Subject: 99 Victoria Drive Bognor Regis PO21 2DZ - BR/3/22/DOC

Planning Application Reference: BR/3/22/DOC

Proposal: Approval of details reserved by condition imposed under BR/281/18/PL relating to conditions 3-Arboreal meeting, 6-Construction Management Plan, 7-landscape scheme, 8-colour scheme of materials and/or finishes, 9-new screen walls and/or fences, 10-covered and secure cycle parking spaces, 12-dustbin enclosures, 13-electric vehicle charging & 14-decentralised, renewable and low carbon energy supply systems.

CONSTRUCTION MANAGEMENT SITE PLAN

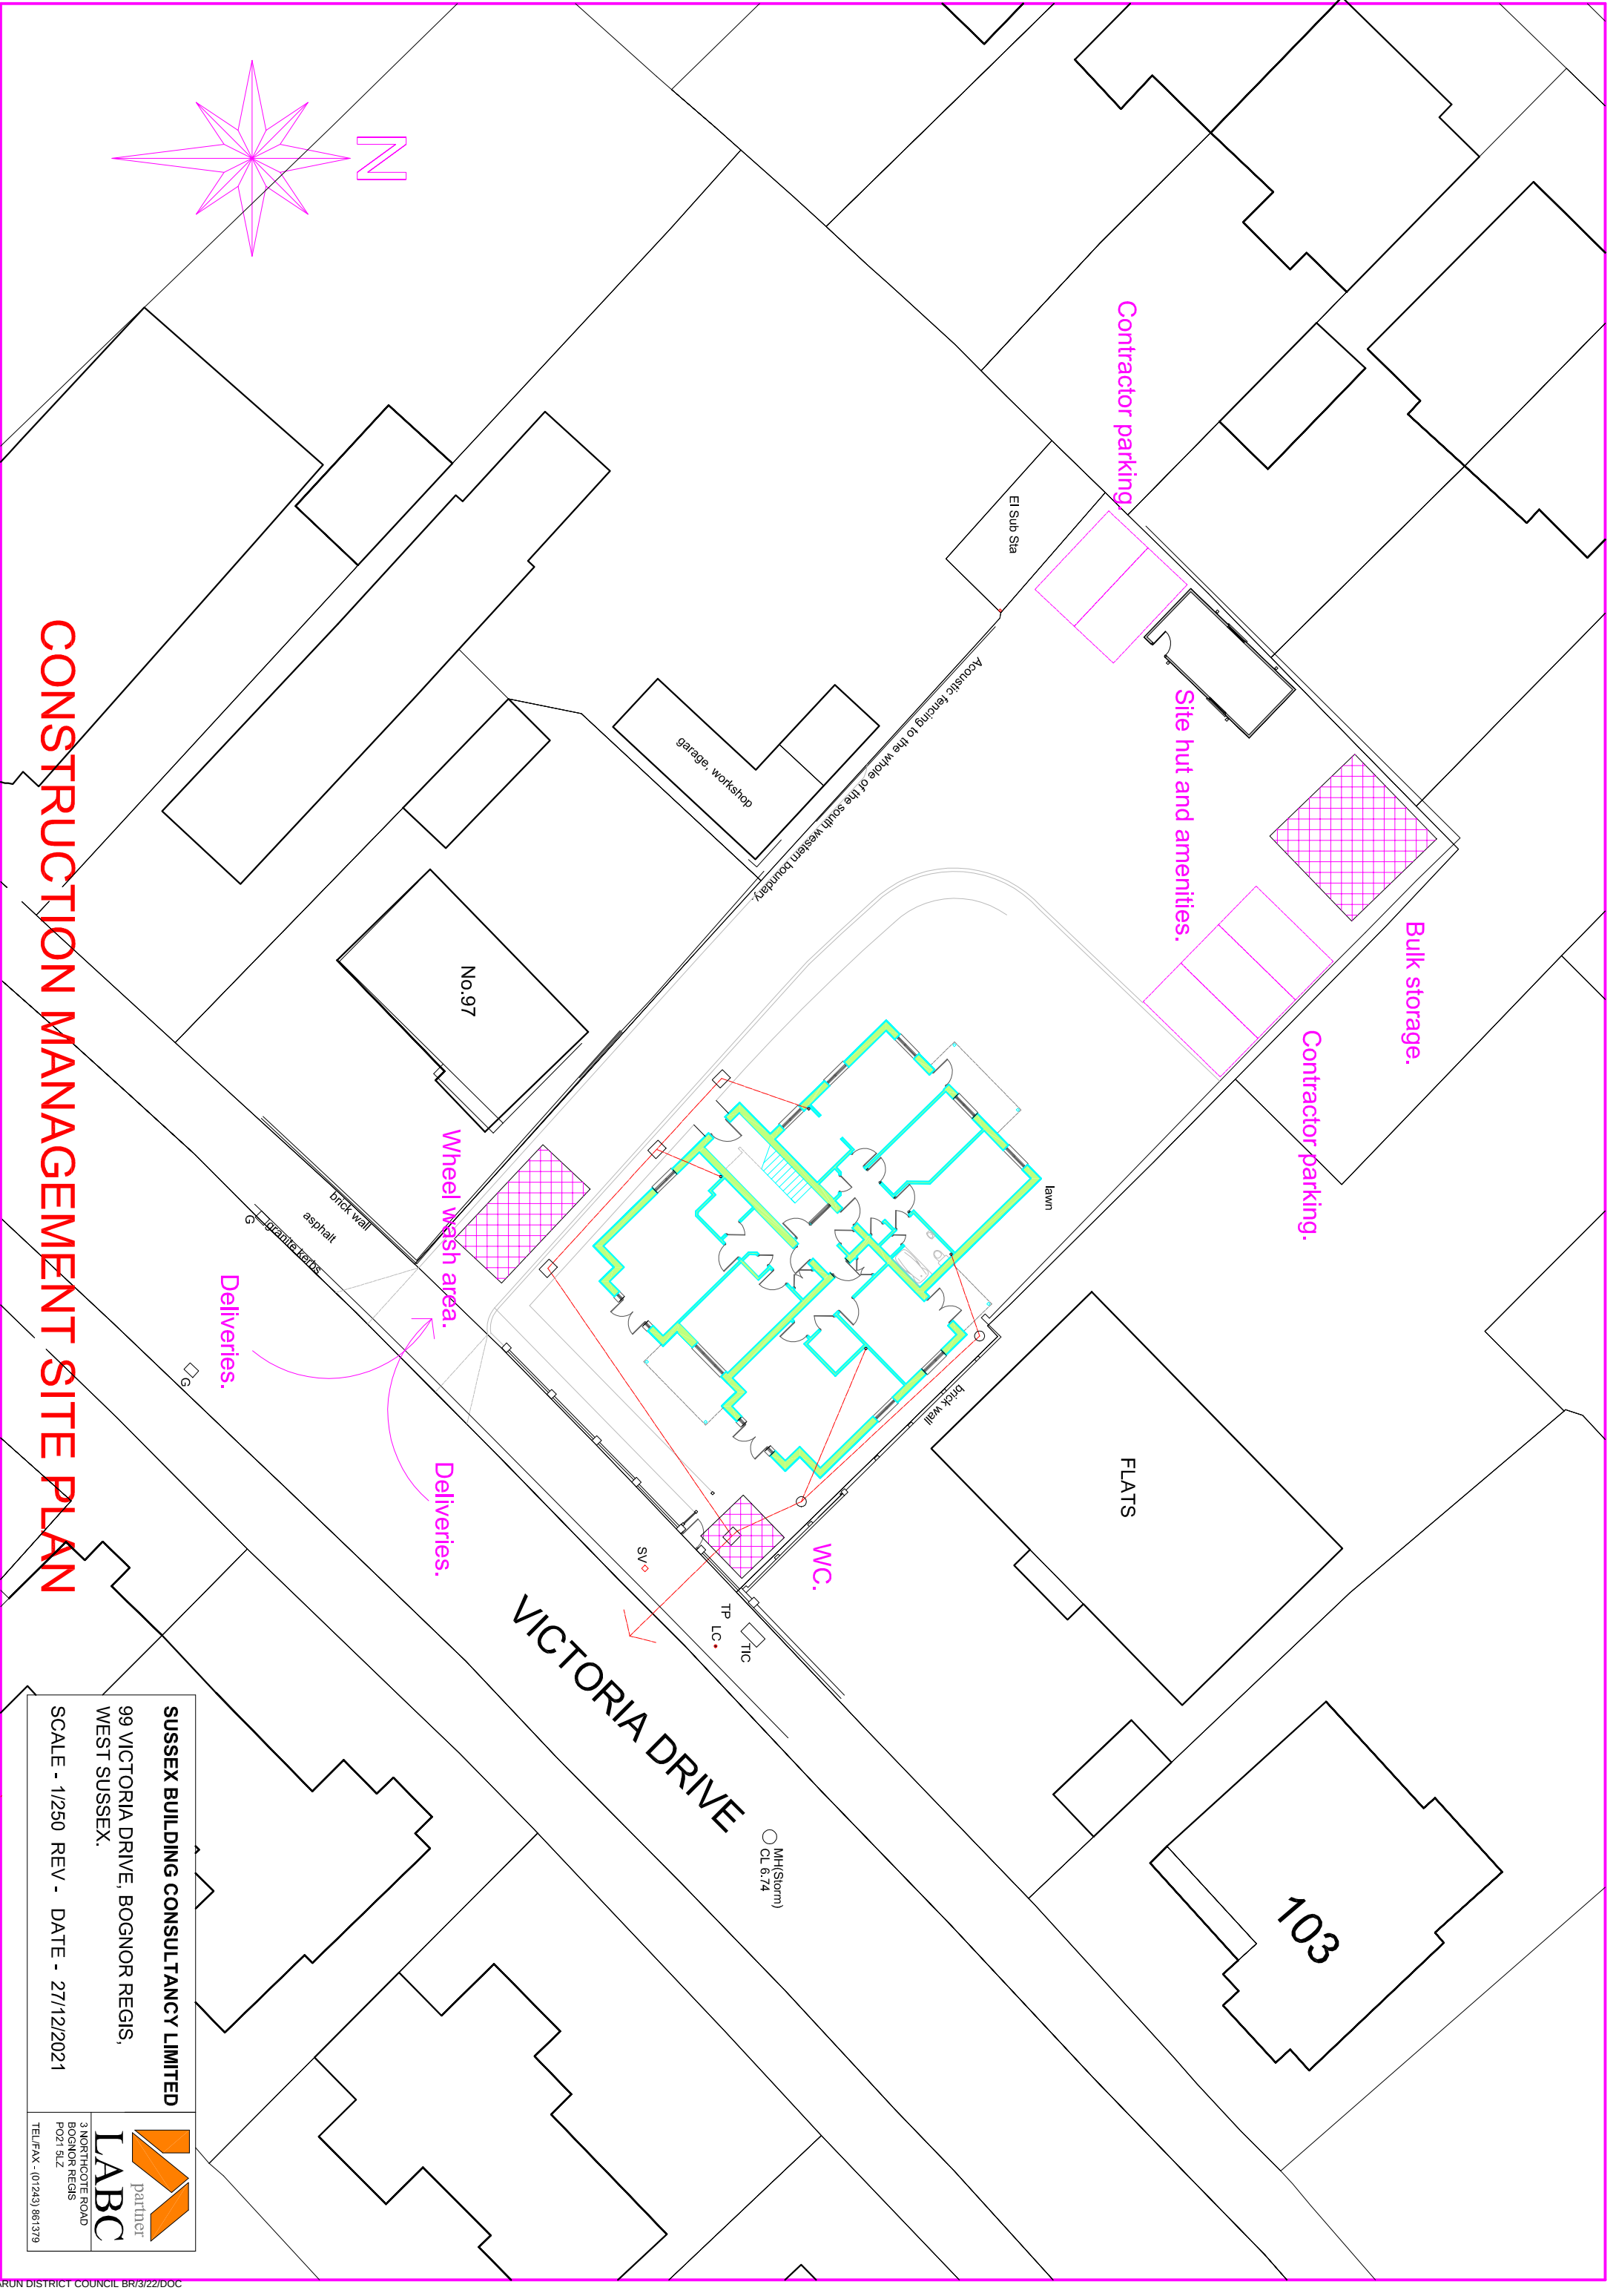
Having reviewed the document entitled 'Construction Management Plan' (no date) [produced by Sussex Building Consultancy Limited], I find the report to be reliable and to meet the requirements of the condition. I therefore recommend the condition can be discharged.

PROPOSED SITE/LANDSCAPE PLAN

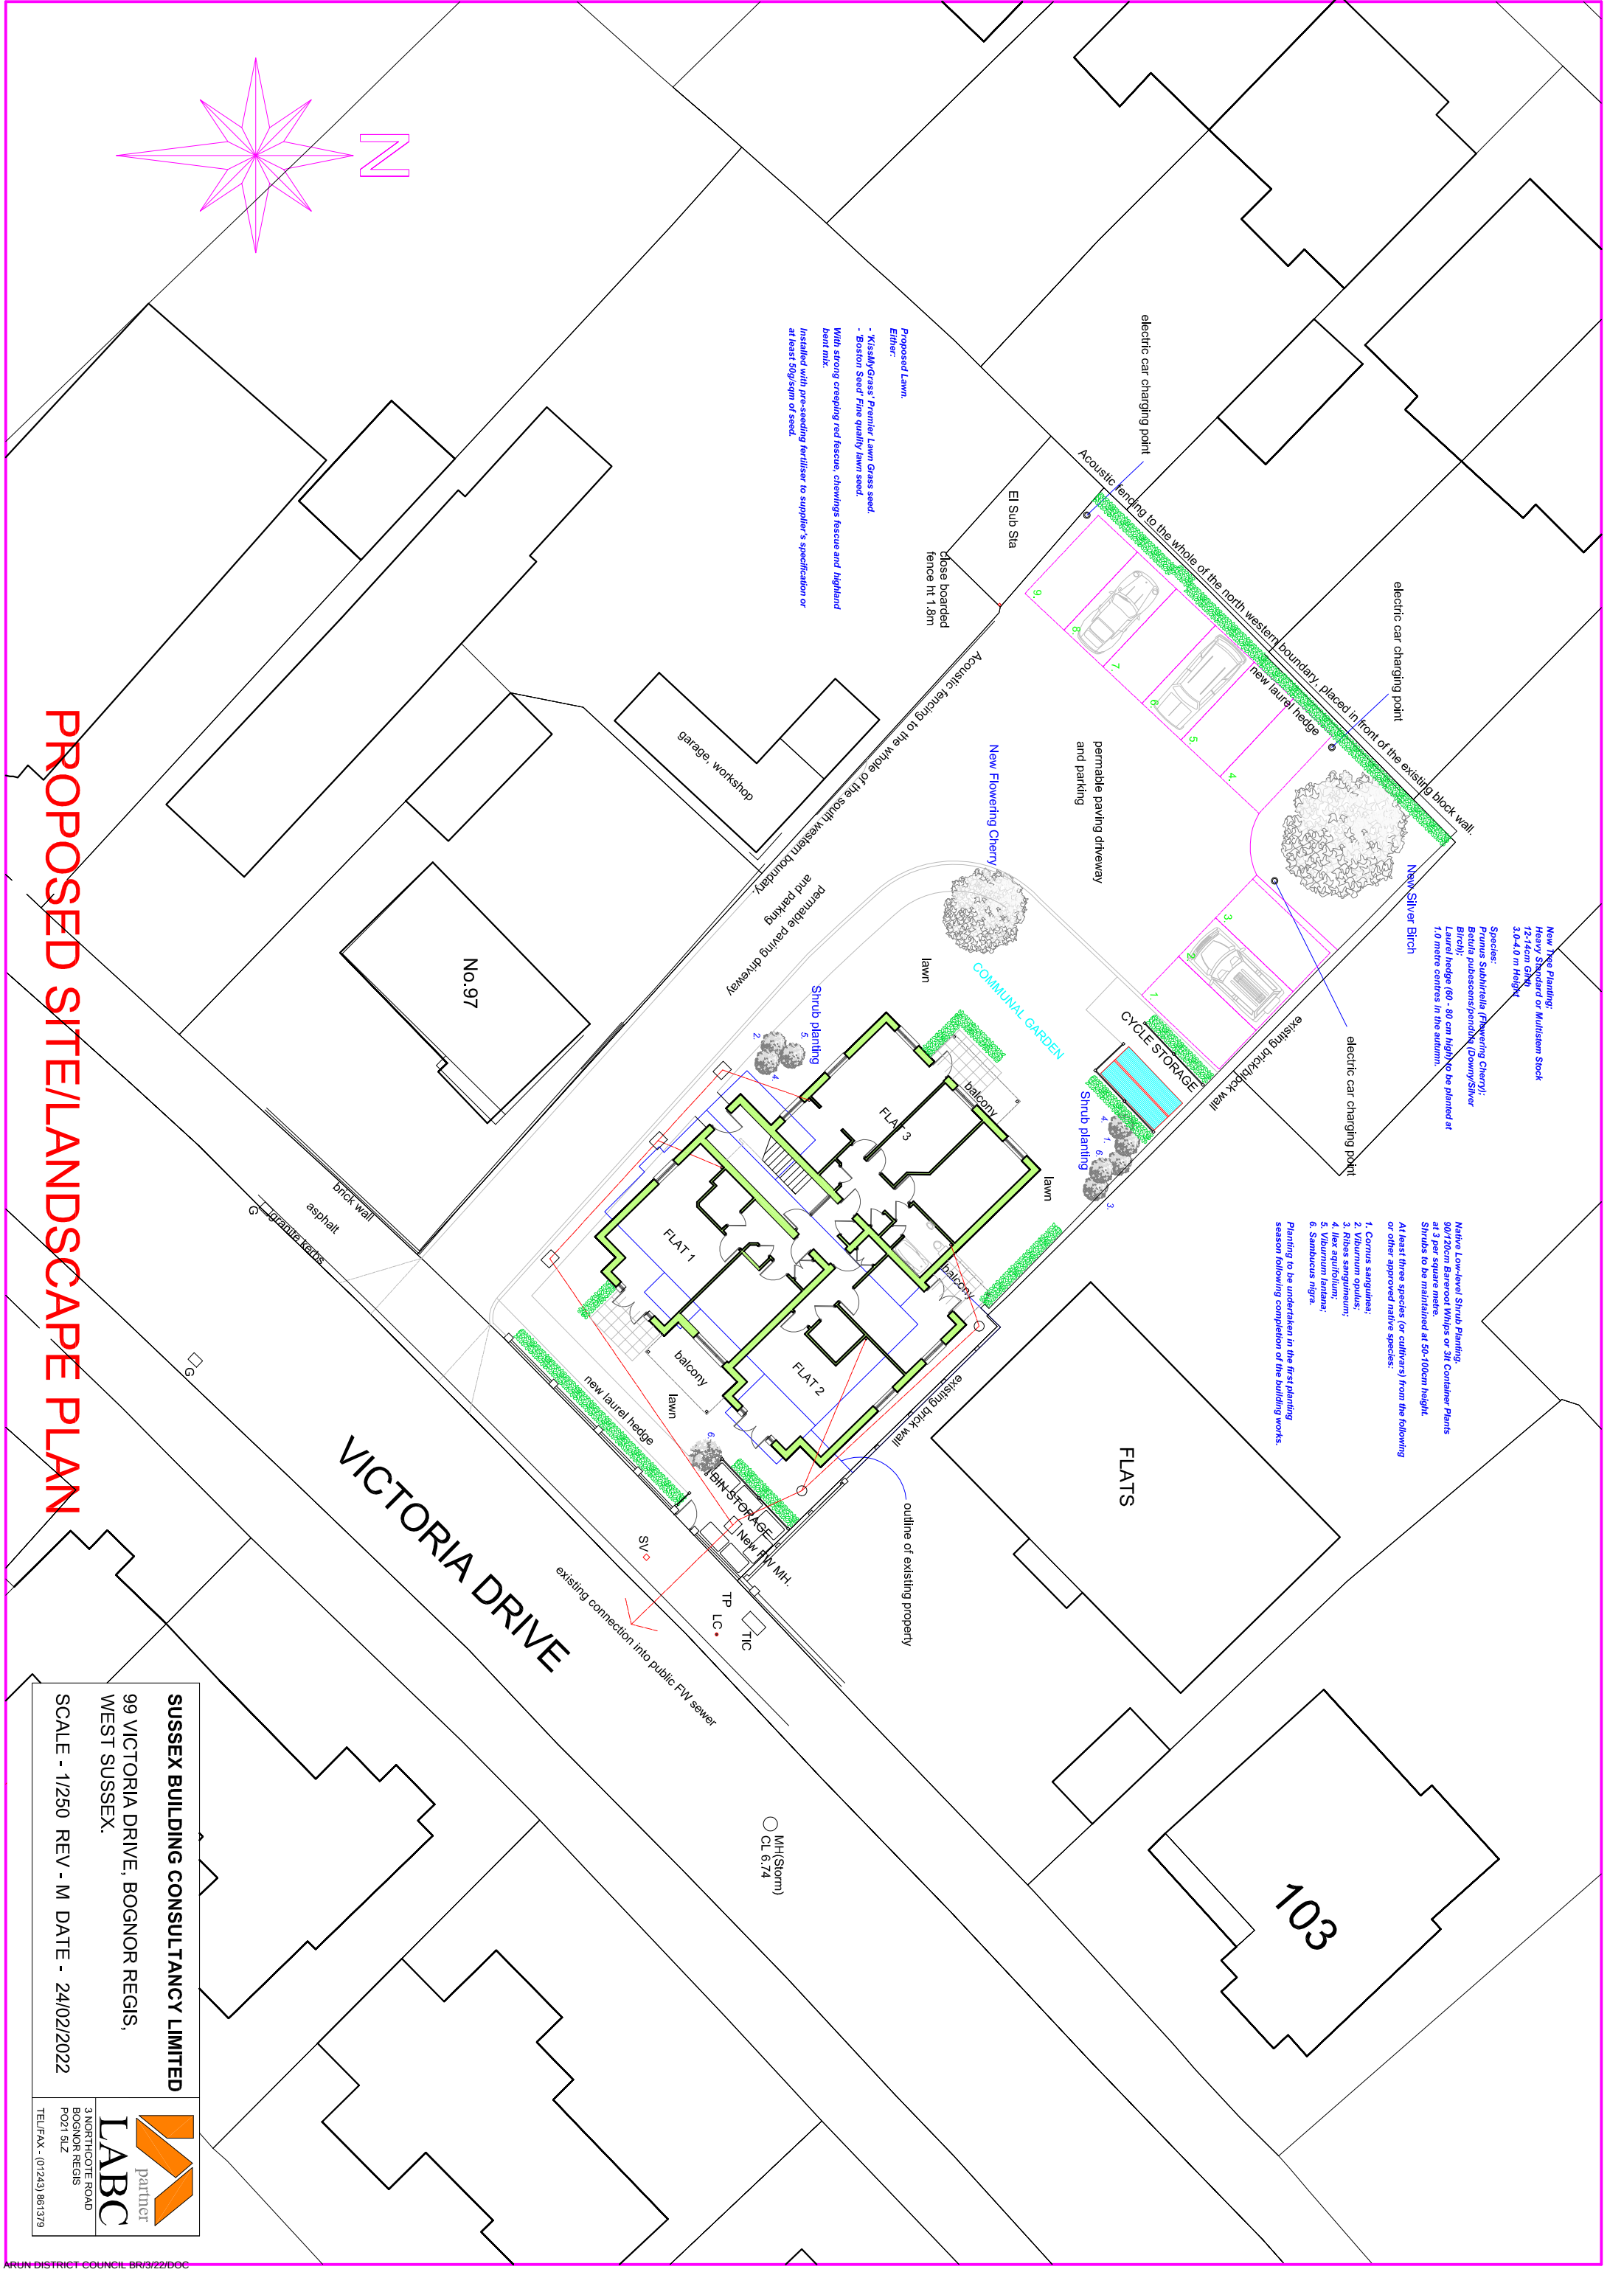
Having reviewed the plan entitled 'Proposed site/landscape plan' (dated 27.12.2021) [produced by Sussex Building Consultancy Limited] I note that the applicant proposes to provide 1 electric vehicle charging point for the 3 flats. Building Regulations approved document 'S' instructs that for new residential buildings with associated parking, there must be an electric vehicle charging point provided for each residential unit within the building – where the number of associated parking spaces is equal to, or greater than, the number of residential dwellings.

Therefore, I request the applicant be required to provide a further two electric vehicle charging points so that the condition may be discharged.
